September 8, 2023

Re: **ALLSUPS #102460**
Project #: PR-2021-006208
Application #: SI-2023-01171

Please find the following responses addressing comments received in a letter dated August 1, 2023. In an effort to address your comments concisely and simplify your review of these development plans, we have summarized your comments and our responses below. Your comment is listed first, followed by the response in Bold.

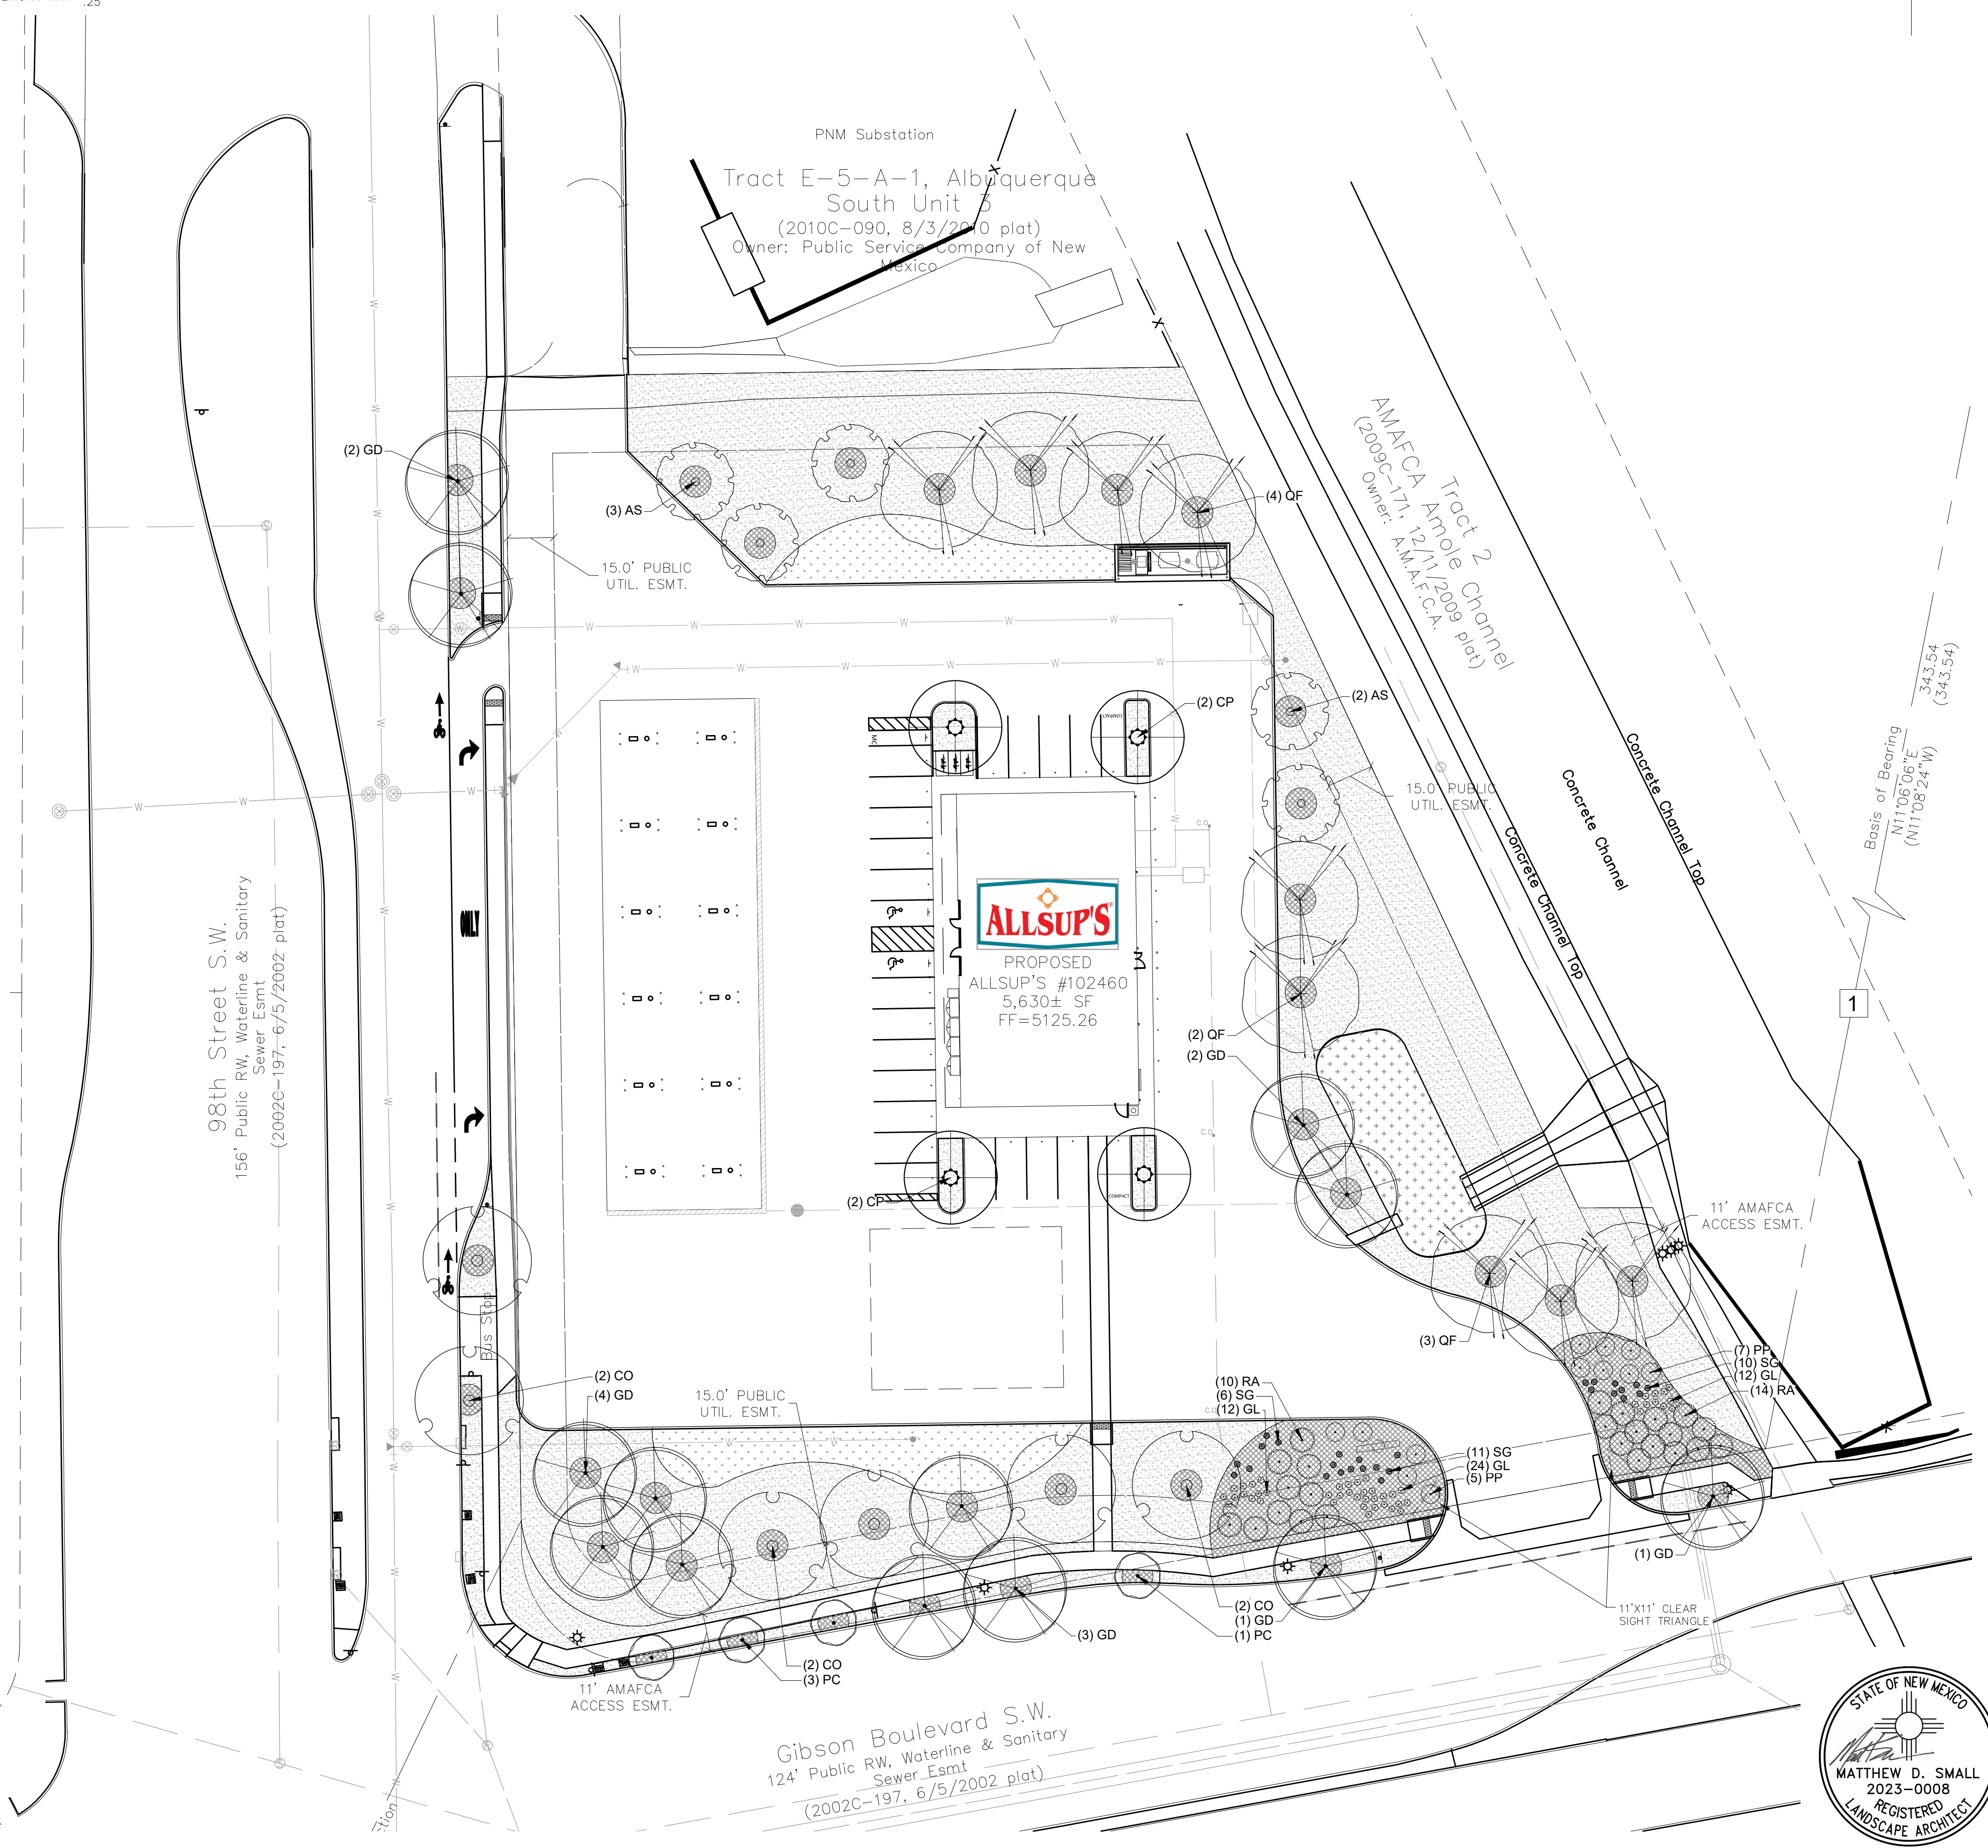
Comment 12: Per 5-6(C)(2) Minimum Landscape Area 5-6(C)(2)(a) a minimum of 15 percent of the net lot area of each development shall contain landscaping. Please show net lot area in calculations to confirm the minimum landscape area requirement is being met. Please note that per IDO 4-3(B)(8)(c) item #3: Warm season grasses may cover up to an additional 70 percent of the landscape area. Blue Grama grass shown on Landscape Plan classifies as a warm season grass

Comment 13: Per 5-6(C)(5)(c) The use of gravel or crusher fines as ground cover is limited to a maximum of 75 percent of any landscaped area. Confirm this requirement is being met and show the calculation in the Landscape Calculations section on the Landscape Plan.

Comment 14: On 5-6(C)(8) Protecting Clear Sight Triangle The clear sight triangle shall be maintained at all exits of parking areas and street intersections. Show Clear Sight Triangle as approved by Transportation on Landscape Plan.

Comment 15: Reference IDO 5-6(C)(10) Planting near Utilities. Trees south of sidewalk on south end of subject property are in Public Utility Easement. Relocate trees in Public Utility Easement north without reducing quantity to ensure street tree requirements are being achieved.

Comment 19: Per IDO 5-6(F)(2) Parking Lot Interior 5-6(F)(2)(a) General At least 10 percent of the parking lot area of lots containing 50 or fewer spaces. Show in Landscape Calculations and in Landscape Plan if this requirement is being met.

There are no parking lot trees. If 24 parking spaces are being provided, 3 parking lot trees are required. Please refer also to IDO 5-6(F)(2)(d) for minimum size of planters for trees.

This requirement does not appear to have been met. Ensure compliance with IDO.

Response 12: Total landscape area provided is 34% of the Site. Calculations updated to show this. Grass type noted.

Response 13: Gravel landscape makes up only 40% of total landscape areas (16,408 SF). Calculations included on LS plan.

Response 14: Clear site triangles included on Landscape Plan

Response 15: Trees have been relocated outside of Public Utility Easements

Response 19: Updated calculations show that new landscape areas in parking area provides 11% of total parking area.

Response 20: 4 Parking lot trees are now included to ensure that no parking space is more than 100' from a tree trunk. Trees are canopy type shade trees.

SCALE 0 15 30  
1" = 30 FEET  
DR. KJK | CH. CBS  
P.M. D. MADRUGA  
BOOK --  
JOB 22003692  
SHEET NO. 40

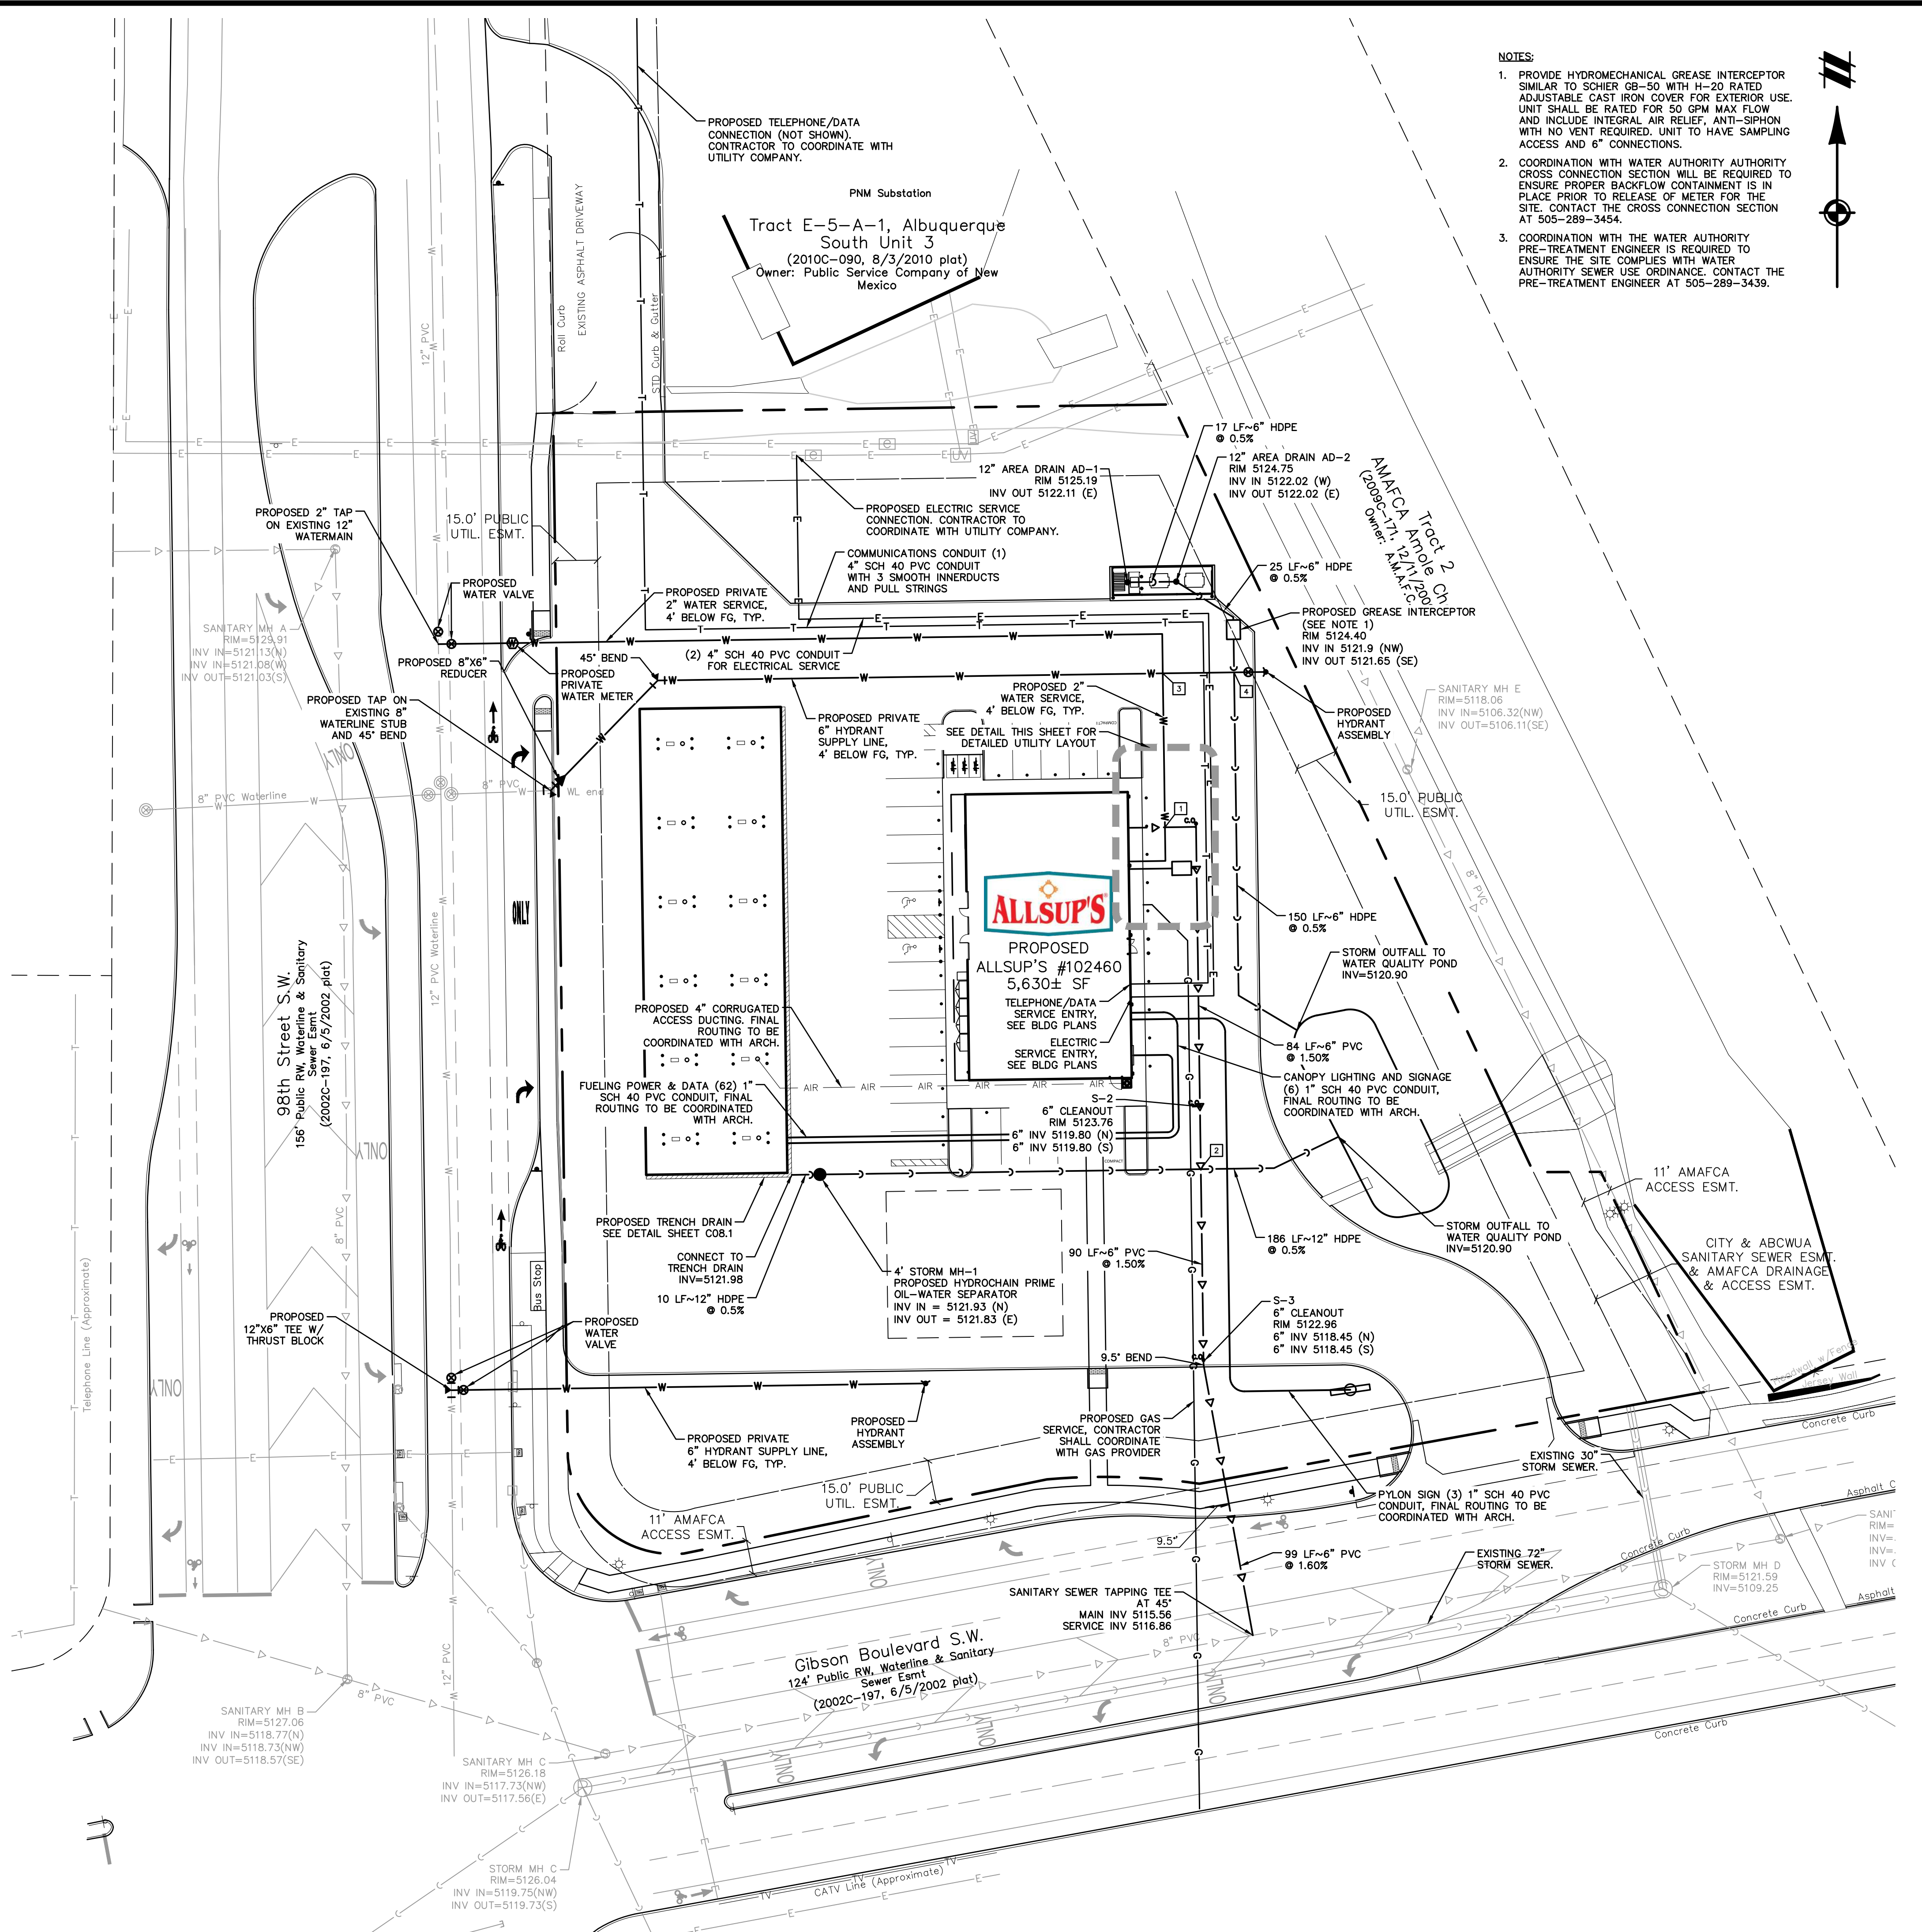
Comment 2: Utility Plan:

- b. Clearly Show existing public water and public sewer mains and any associated easements on the utility plan.
 - i. Please clearly label public vs. private water and sanitary sewer infrastructure. Note all public infrastructure not constructed with this building permit but with other permit.(Connection permit can be used or work order)

- c. Dimension the public water and public sewer easements on the utility plan.

- e. There shall be no trees, parallel fences/sidewalks/curbs, or structures within the public water and public sewer easement. Please revise accordingly.

- f. Please add the following notes to the Master Utility Plan
 - i. Coordination with Water Authority Cross Connection Section will be required to ensure proper backflow containment is in place prior to release of meter for the site. Contact the Cross Connection Section at 505-289-3454.
 - ii. Coordination with the Water Authority Pre-Treatment Engineer is required to ensure the site complies with Water Authority Sewer Use Ordinance. Contact the Pre-Treatment Engineer at 505-289-3439.

Response 2: Utility plan is Sheet 4.0 in the plan set. Proposed services are updated to meet the requirements of the Availability Statement.

Response 3: All utilities have been labeled as public or private on the plans.

Response 4: Public utility easements have been labeled on plan.

Response 6: Trees have been shifted outside of public utility easements.

Response 7: Notes added to utility plan upper right corner.

**D1** SCALE 1/4" = 1'-0" **EXTERIOR ELEVATION - SOUTH**

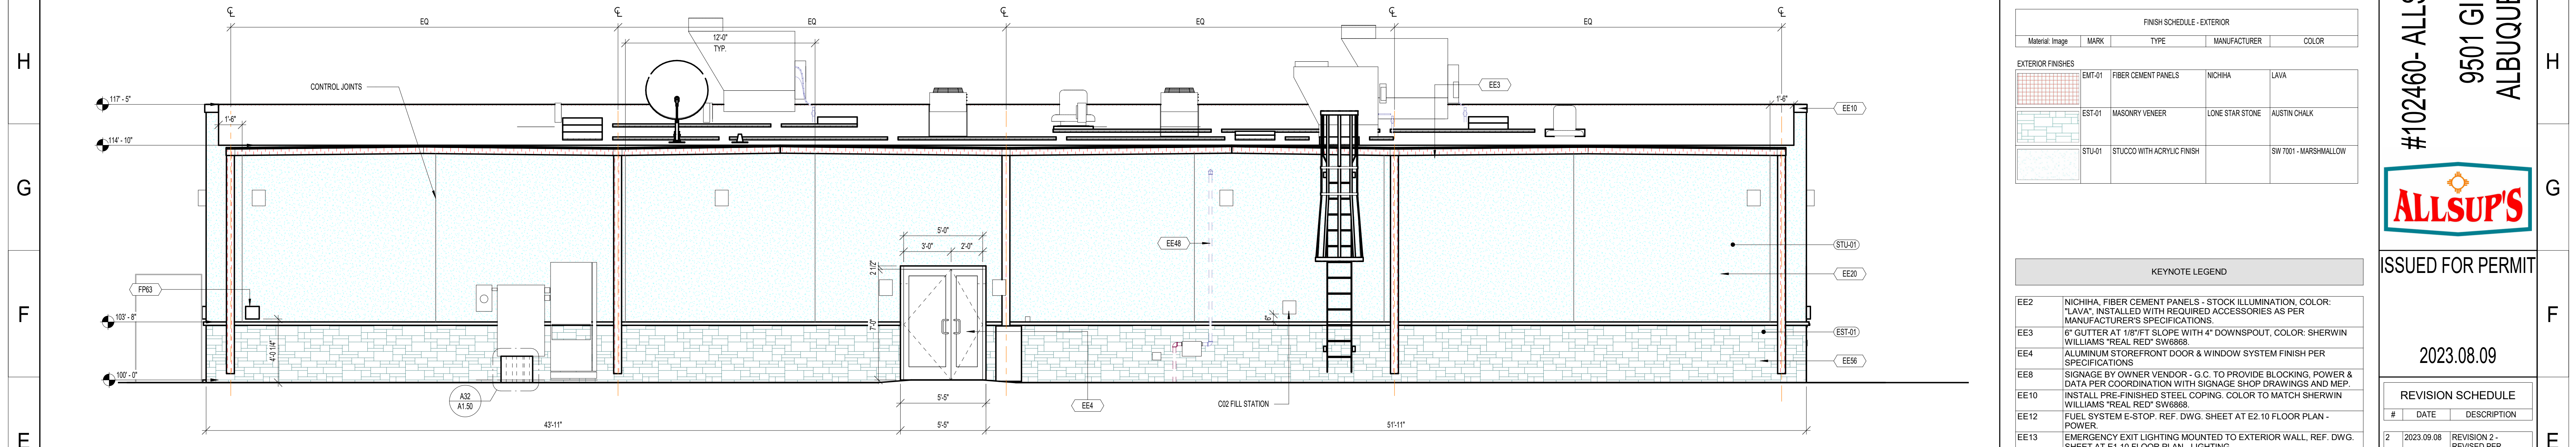
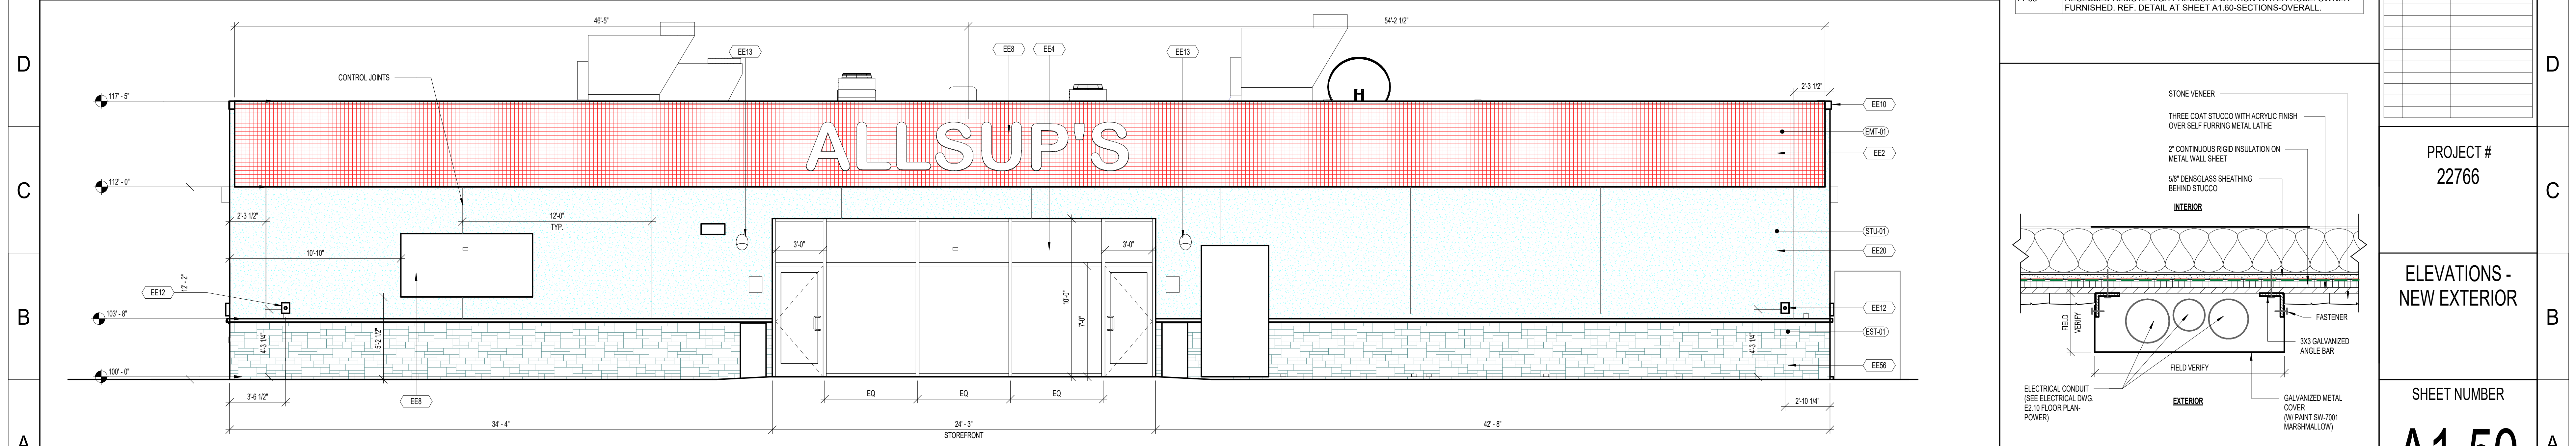
Comment 7: Please provide a detailed explanation letter and include site plan notes as to how the proposed elevation is meeting all applicable sections of 5-11(E) of the IDO.

Comment 8: All signage must meet requirements of IDO 5-12, Table 5-12-2, and be submitted under separate permit. Please confirm on site plan the distance from the property line to the proposed pylon sign

This site has 2 street facing façades (98th and Gibson). From the property line to the closest point on the street facing façade along 98th is approximately 144'. From the property line to the closest point on the street facing façade along Gibson is approximately 141.5'. Since the street facing facade exceeds 30ft from the property line 14-16-5-11(E) is not applicable.

Response 11: Signage table included on A1.50 to show building signage is less than 15% of façade area (267 SF allowed, 93 SF proposed). Note included to state signage is being permitted separately. Distance from pylon sign to property line included on site plan.
